**KIRKLEES METROPOLITAN COUNCIL
INVESTMENT & REGENERATION SERVICE**

**DELEGATED DECISION FOR APPLICATION FOR CERTIFICATE OF
LAWFUL DEVELOPMENT**

Reference no.: 2026/CL/91184/E

Site: 38, Trafalgar Street, Healey, Batley, WF17 7HA

Permitted Development
 Client
 Mrs Bushra Razaq
 Drawing No.
 1
 Date 20/04/2026 Scale 1:100

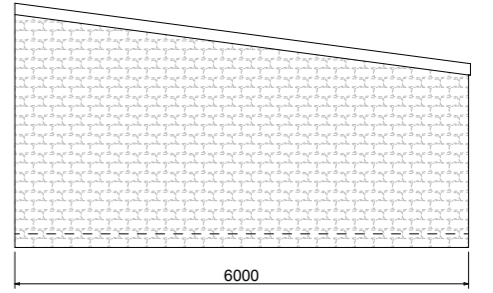
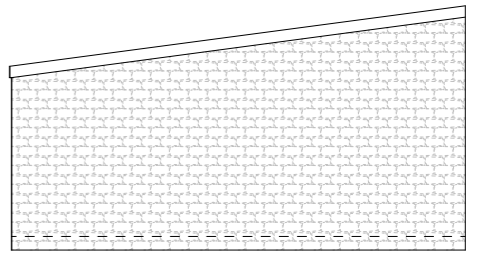
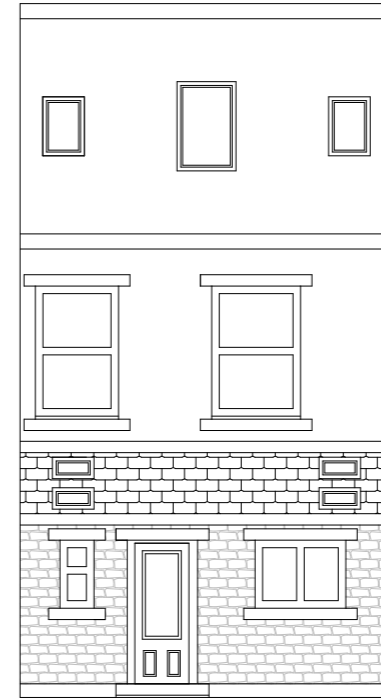
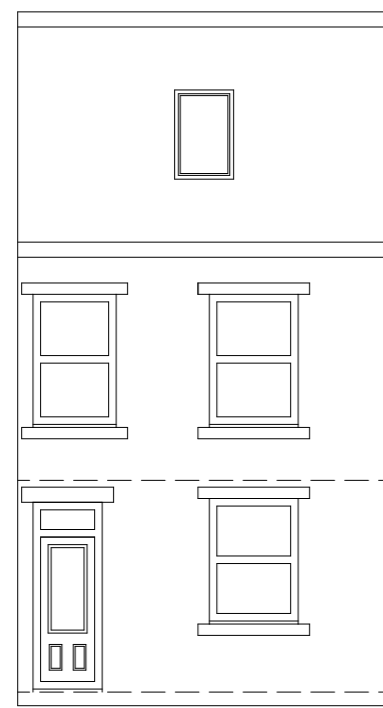
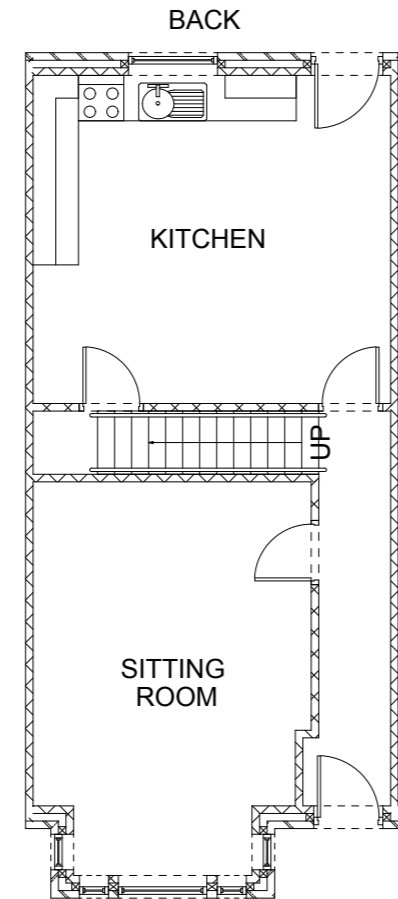
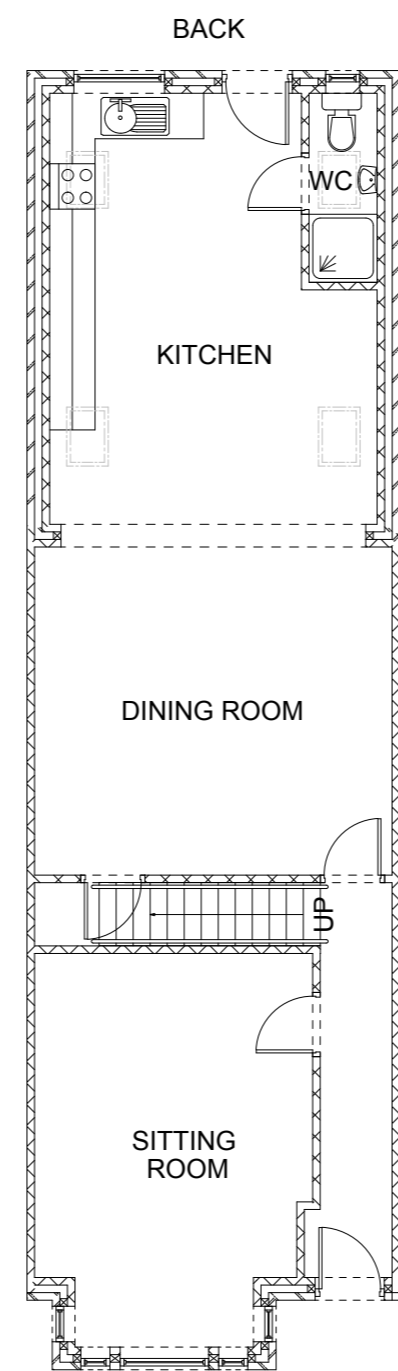
The proposed extension would span the full width of the rear elevation and would project 6 metres in total. The eaves height would be 2.3 metres with an overall height of 3.3 metres.

Comment: *The enlarged part of the dwellinghouse would have a single storey and would extend beyond the rear wall of the original dwellinghouse by more than 3 metres but it does not exceed 4 metres in height.*

Comment: *The enlarged part of the dwellinghouse would have a single storey and would not extend beyond the rear wall of the original dwellinghouse by more than 6 metres and it does not exceed 4 metres on height.*

Comment: *The enlarged part of the dwellinghouse would be within 2 metres of the boundary of the curtilage of the dwellinghouse however the eaves height would not exceed 3 metres.*

In this case, as assessed above, the works would fail to comply with paragraph A.1(f). Therefore, Condition A.4 is of relevance:

Comment: The applicant has not demonstrated and neither does the Local Planning Authority have any record to confirm the Authority determined that prior approval is not required or has been given. Consequently, and even if it was considered the above limitations had been met, should the development had begun at the time of this application it would have been in breach of condition A.4 and therefore would have been deemed unlawful.
